**Consultation Response from KC,
Lead Local Flood Authority**

2025/91844 Foxhall Environmental Services Ltd, Owler Lane, Birstall, WF17 9BW

Redevelopment of site to include erection of 3 light industrial units, prefabricated offices and waste transfer station shed and open storage

Date Responded: 09/09/2025.

Plan No.
FOX/BIR/IND/PL/03

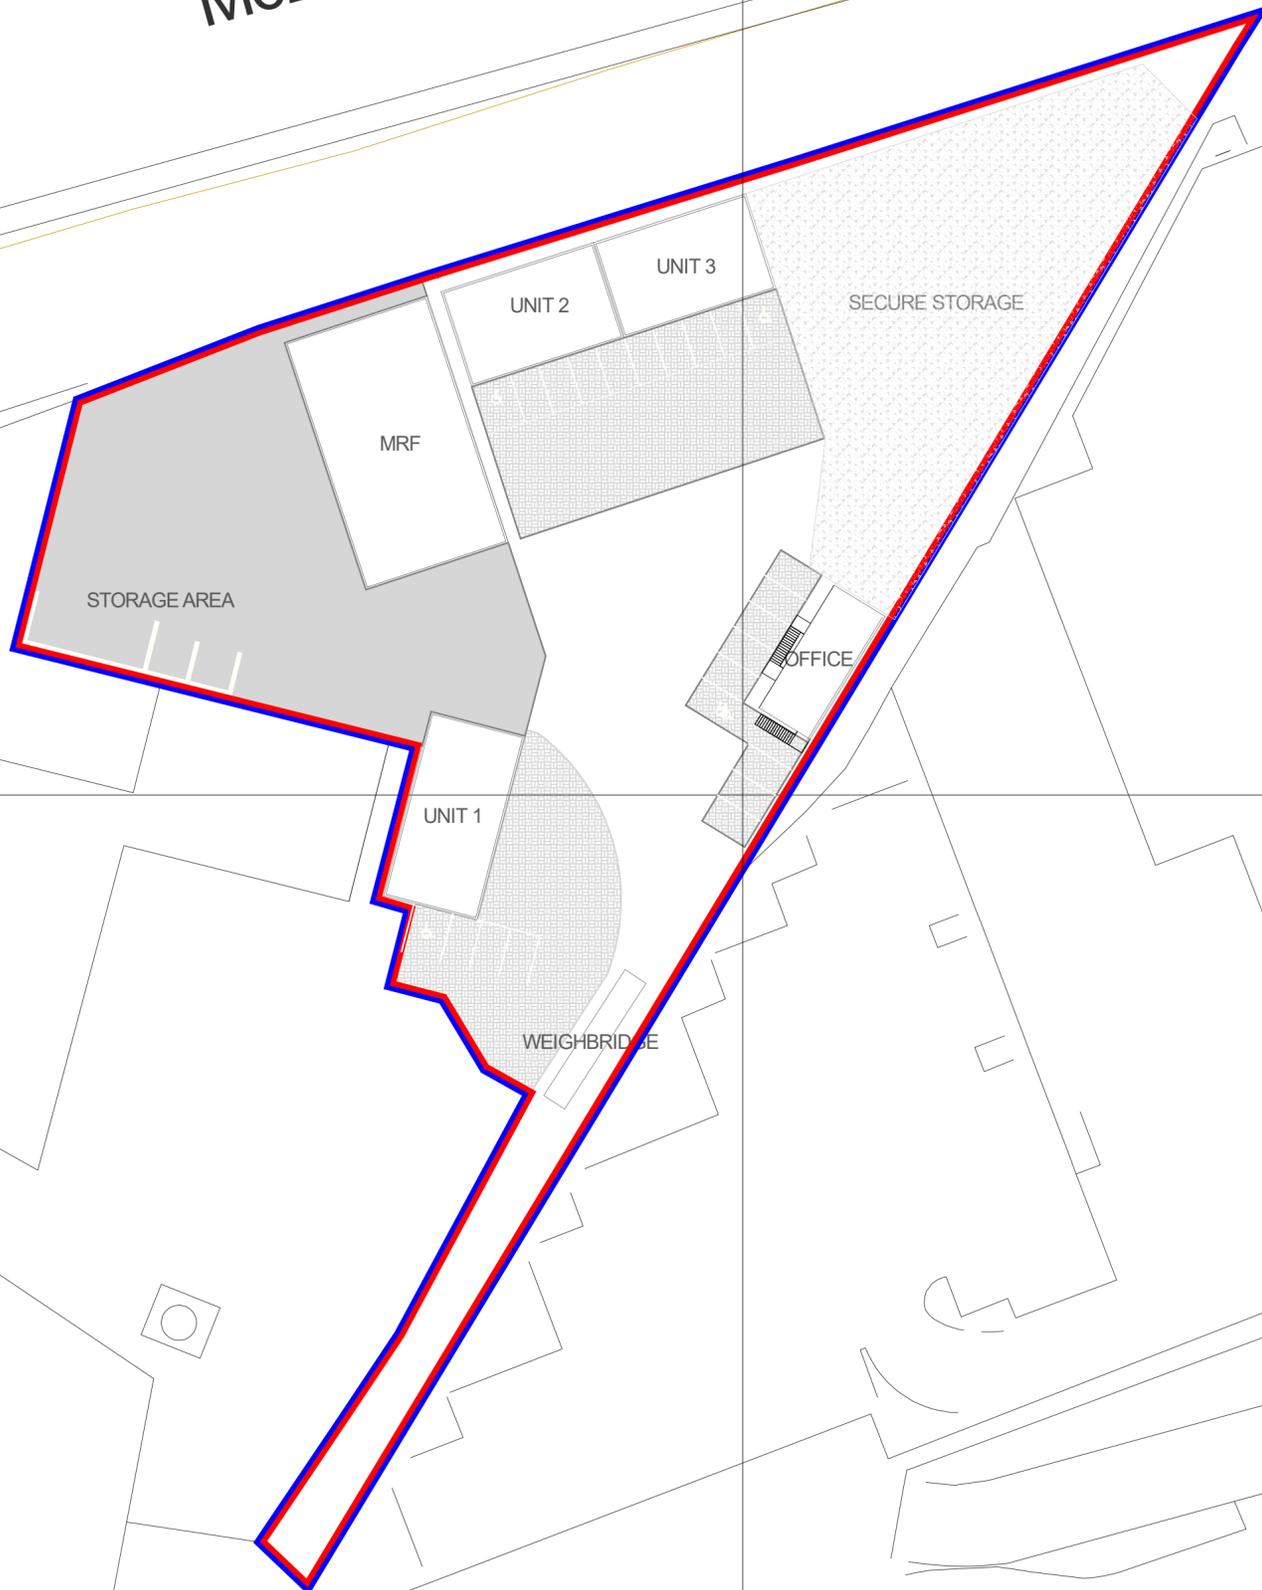
It is noted that in the GeoSmart Drainage Strategy that a combination of soakways and attenuated discharge to sewer is proposed.

BGS data held by Kirklees Council indicates that the area in the north-east corner of the site adjacent to the M62 motorway is at risk of ground stability. It appears that the motorway is in cutting at this point with the motorway some 5.0m below the site, therefore there is a risk of re-emergence of infiltrated surface water within the embankment that could result in collapse.

Therefore, the LLFA would prefer that the surface water disposal from the new development to be by positive drainage by gravity to the public sewer in Owler Lane at an attenuated rate equivalent to 70% of the existing run-off rate (subject to agreement with Yorkshire Water and a minimum diameter of the flow control device outlet of 75mm) with attenuation storage provided sufficient to ensure no off-site discharge of surface water for the 1 in 100 year rainfall event (plus an allowance for climate change).
